## Hearing Action Points

Application by Highways England for an Order Granting Development Consent for the A1 Birtley to Coal House Improvement Scheme

The following are the agreed actions arising from the **Issue Specific Hearing** (ISH1) on the draft Development Consent Order (DCO) held at the European Suite, Newcastle Gateshead Marriott Hotel, MetroCentre, Gateshead, Tyne and Wear NE11 9XF on **Tuesday, 21 January 2020**.

Project Title: A1 Birtley to Coal House Scheme

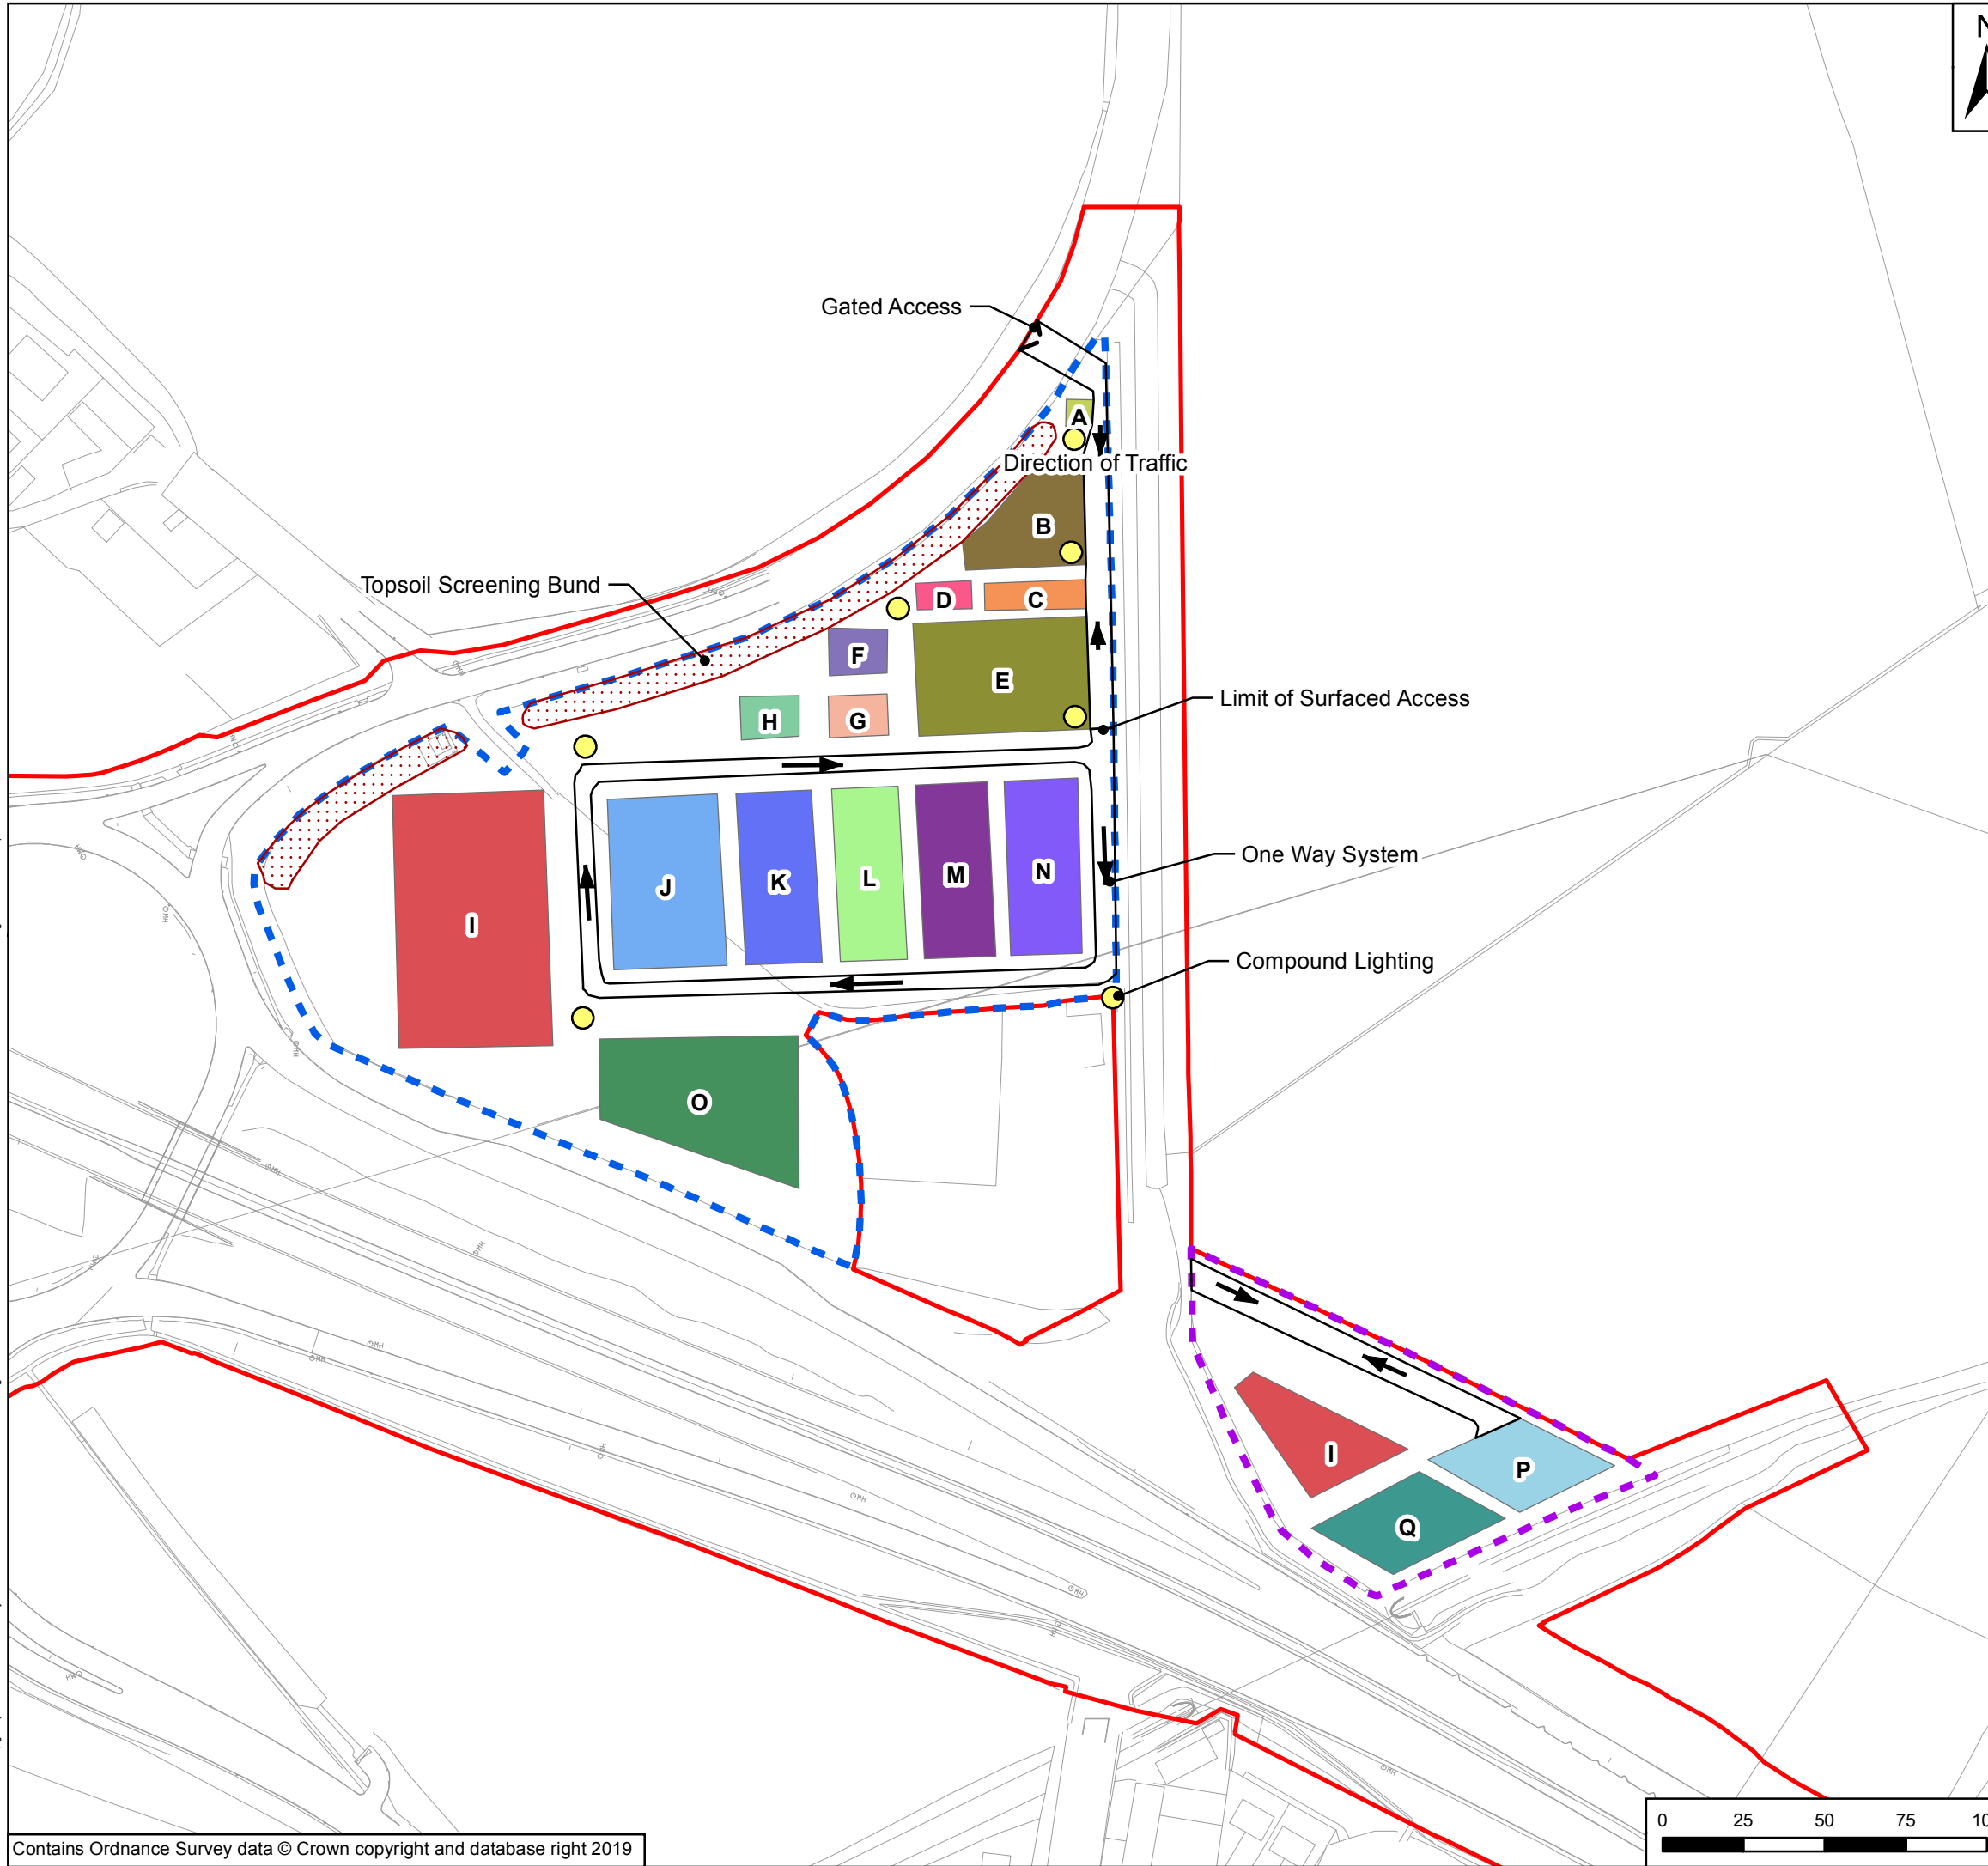
9	Schedule 1, ...further development a) – Provide an update on progress of discussions between Northern Gas Networks and the Applicant in relation to the detail of the layout within the construction compound adjacent to J67. Consider if further clarification is needed, either within the dDCO or the CEMP.	Applicant and Northern Gas Networks	D2
10	Article 37 – Consider implications of the removal of hedgerows and include details of the Council's position in the Statement of Common Ground (SoCG)	Gateshead Council	D2
11	Schedule 9 – Confirm that TPO No.21 is the correct reference and submit a copy of the TPO for the Examination	Gateshead Council / Applicant	D1
12	Schedule 1 – Provide justification for the necessity of each of the 'in connection with' works (a to v)	Applicant	D2
13	Explanatory Memorandum, Schedule 1 Authorised Development – add missing words ' <i>and associated development</i> ' to the first paragraph	Applicant	D2
